## Chapter Eighteen ◆ Soils, Hydrogeology and Ground Conditions

- 18.1 This chapter provides an assessment of the geoenvironmental information and likely significant effects of the Proposed Development in terms of soils, hydrogeology and ground condition impacts with respect to the Project Site. This chapter was originally published in December 2020 but has since been updated (July 2021) to reflect; the notification of the Swanscombe Peninsula as a SSSI, changes to the proposed development, additional work undertaken with respect to ground conditions and further information received. Consideration has been given to the Project Site conceptual models including geology, hydrology, hydrogeology and the geoenvironmental conditions (including issues associated with soil gases, chemicals within soils and groundwater). A range of impacts associated with the design, construction and operation of the Proposed Development have been assessed.

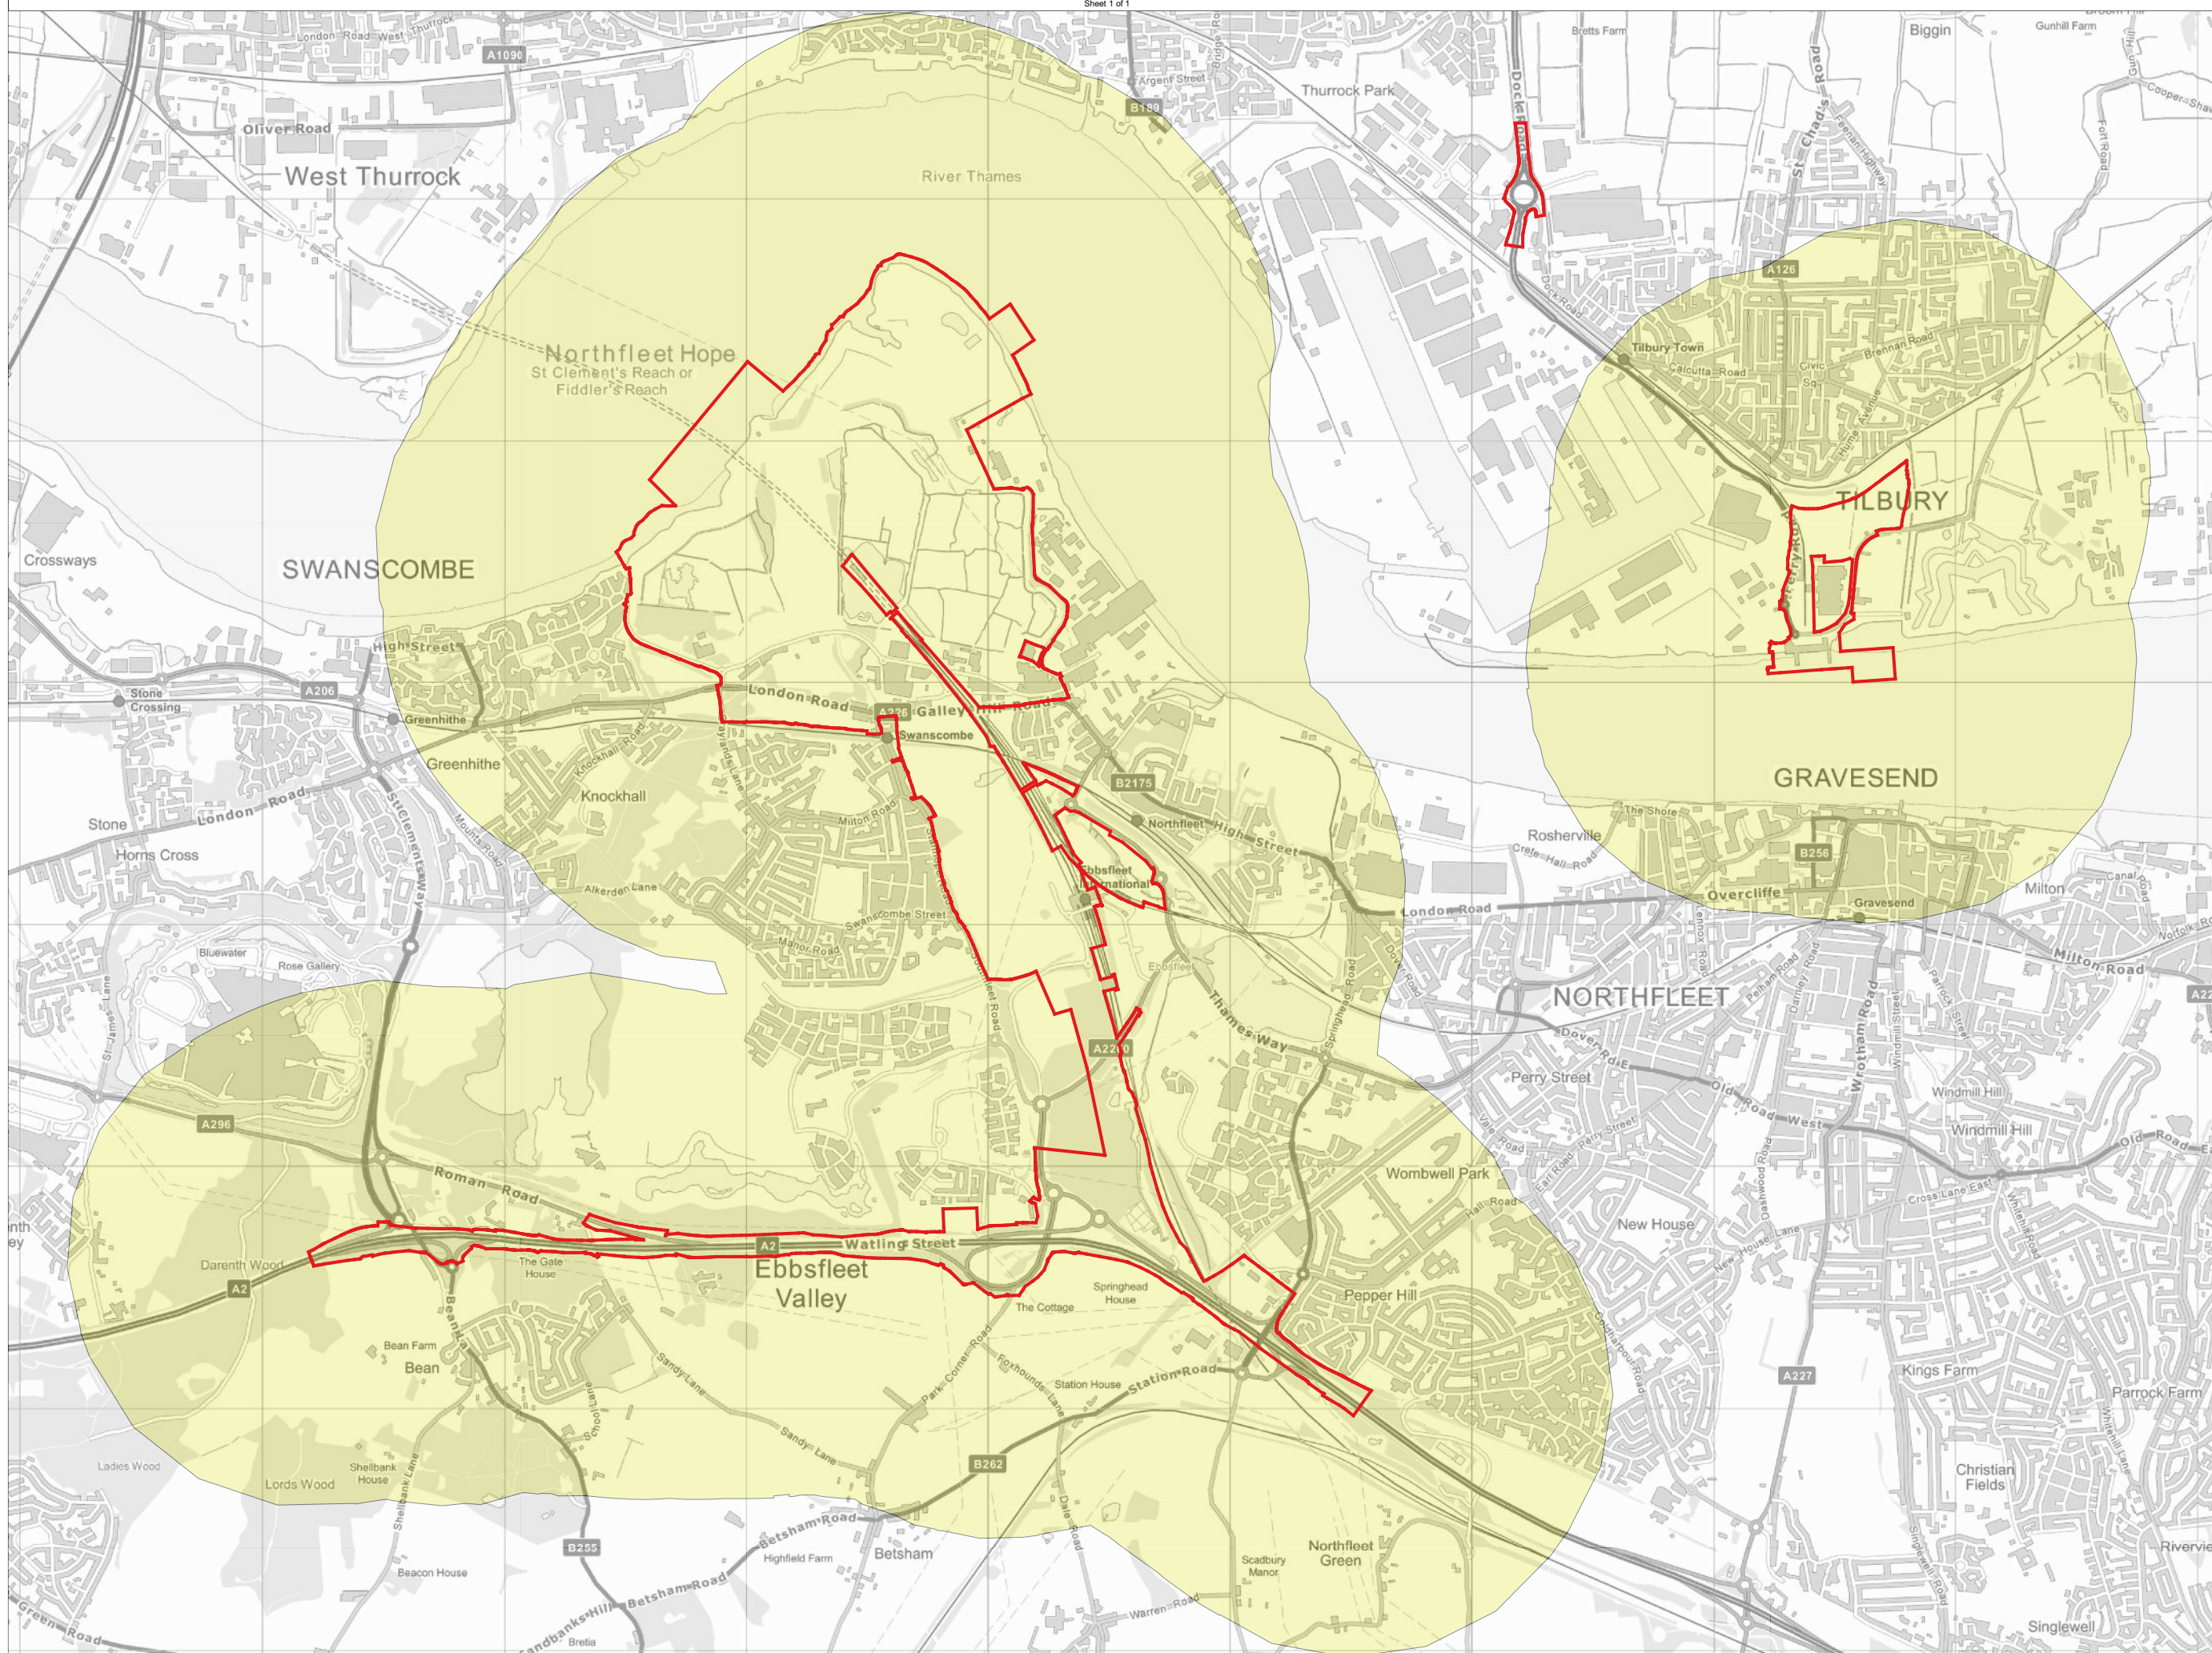
Ebbsfleet DC	With regards to the study area for contamination / ground conditions, it was stated <i>'These areas should be clearly described within the ES and illustrated on a figure/plan.'</i>	The study area (DCO Order Limits with 1km buffer) is illustrated by Figure 18.1.
Ebbsfleet DC	Ebbsfleet DC noted that some guidance, legislation and policy relevant to contamination was referenced inaccurately, namely The	Legislation, policy and guidance relevant to contamination has been updated.
